# CITY OF ALBUQUERQUE

**RE: Raising Cain's C0705**  
**2004 Wyoming Blvd NE**  
**Grading and Drainage Plan**  
**Engineer's Stamp Date: 12/15/2022 (Invalid – Please correct)**  
**Hydrology File: H20D003D**

Based upon the information provided in your submittal received 12/15/2021, the Grading & Drainage Plan is **not** approved for Building Permit, SO-19 Permit, and for action by the DRB on Site Plan for Building Permit. The following comments need to be addressed for approval of the above referenced project:

GRADING PLAN

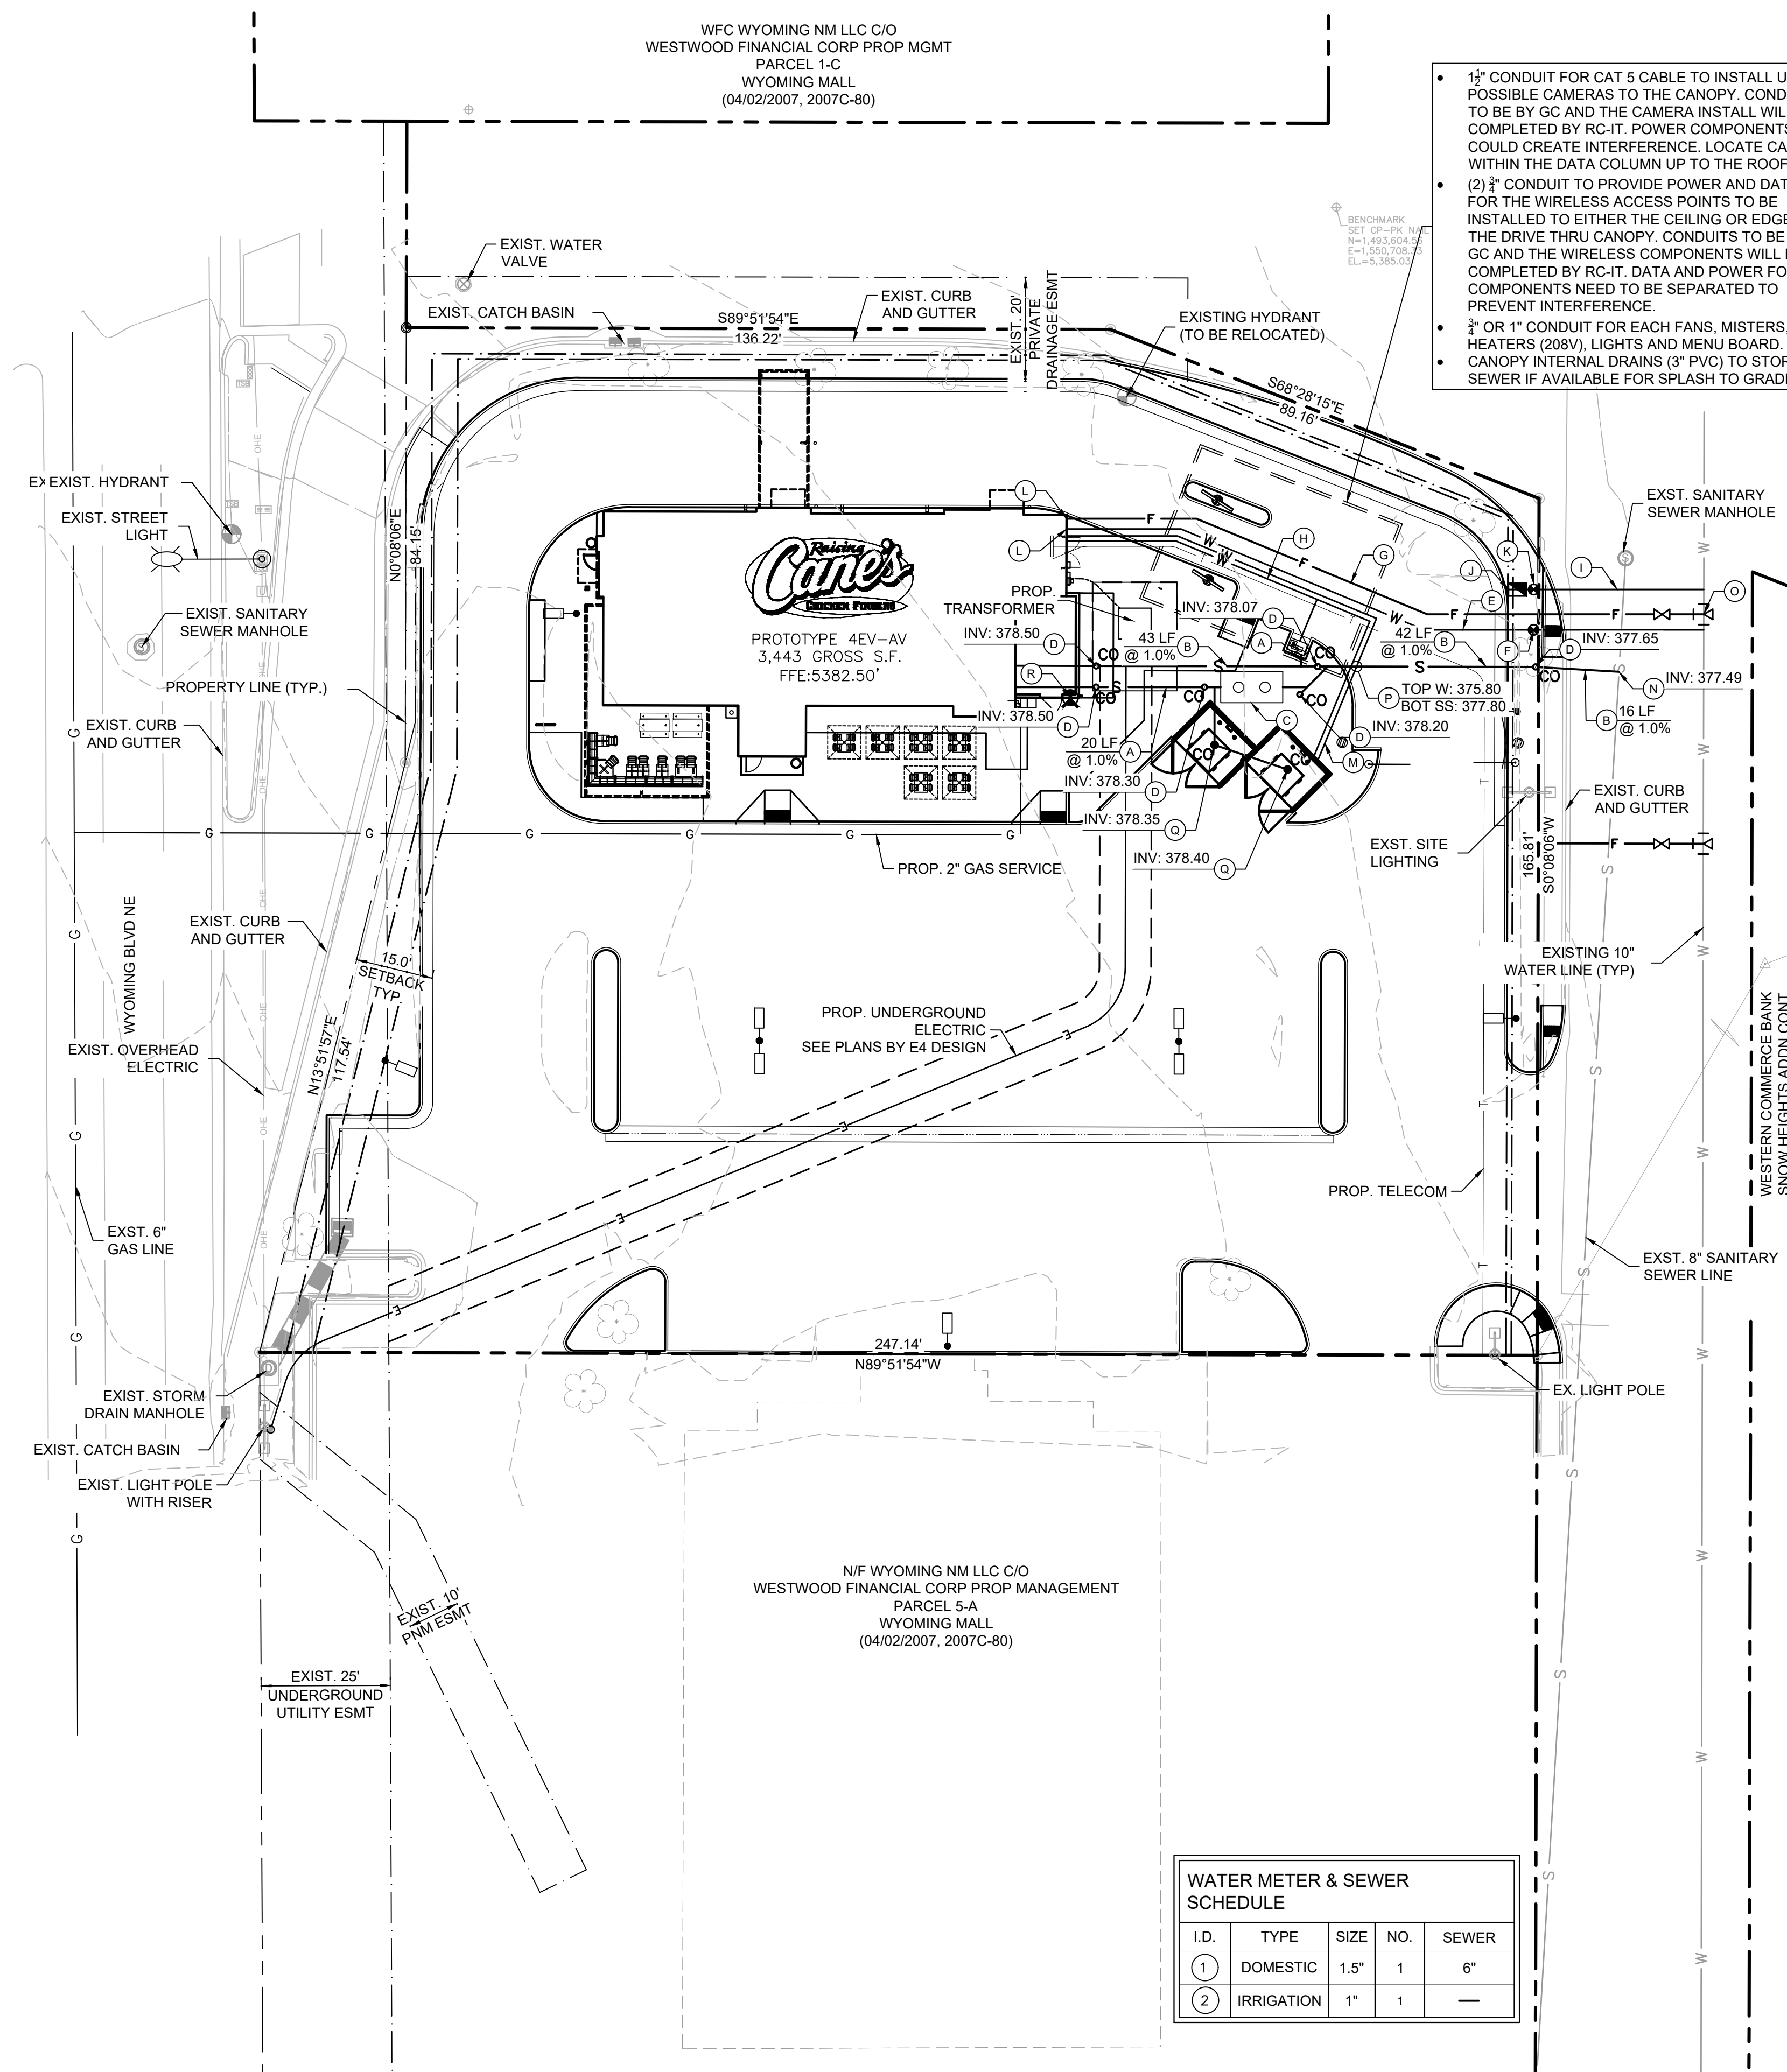
1. Please provide containment for trash enclosures per DPM Chapter 6-12(D)(2)
  - a. **Section 6-12(D)(2) Restaurants and Commercial Food Processing** These land uses shall provide a drain in the trash enclosure (i.e. dumpster) pad that drains to the sanitary sewer. On-site stormwater shall not drain onto the trash enclosure pad, and the pad shall be graded to the drain. A berm around the pad may be required to ensure that stormwater runoff from the site will not mix with stormwater falling on the trash enclosure pad.

2. Please see engineer stamp date and revise with new corrected stamp date. It is currently dated 12/15/**2022** and correctly reference the correct year.

3. The legal description notes that there is a lease agreement that shows the Raising Cane's site however the south portion of the lot needs to also be included on the G&D and should include interim grading conditions that will include a silt pond prior to drainage into the public storm system.

4. Please see existing inlets for south portion of the lot. I assume they will be utilized for future plans. Please note to protect in place.

5. Please include the DPM calculations and information on the G&D Sheet to include existing vs. proposed and the narrative summary. Please note existing instead of pre-development as the site is actually developed but is be redeveloped for different use.

6. Provide a Storm Water Quality pond (s) once these calculations have been completed as required per the DPM Chapter 6. Also complete the drainage covenant for the ponds. (attached)

7. For the south portion of the lot, include an interim grading plan that includes a silt pond prior to draining into the existing storm system.
8. Please add a note under Grading Notes. "Side slopes need to be stabilized with Native Grass Seed (per City Spec 1012) with Aggregate Mulch or equal (Must satisfy the "Final Stabilization criteria" CGP 2.2.14.b.)".

9. Please provide the FIRM Map and floodplain note with effective date.
10. Please include project benchmark and datum.
11. Per the DPM Chapter 6, 24"x36" is currently the City's standard. This applies to all site plans, Grading & Drainage Plans, Traffic Circulation Plans, DRC Plans etc. Please resubmit with this plan size.

12. Please provide the SWQV calculations for each basin draining to each pond. The stormwater quality ponds need to be sized for the areas draining to them.

13. Payment in Lieu (Amount =  $207CF \times \$8/CF = \$1656$ , per sheet C-002) of onsite management of the SWQV must be made. Take three copies of the treasury deposit slip to the Treasury and then include one copy of the paid deposit slip when resubmitting.

14. Include details about historical flows (existing) and proposed and the difference between the two based on DPM calculations.
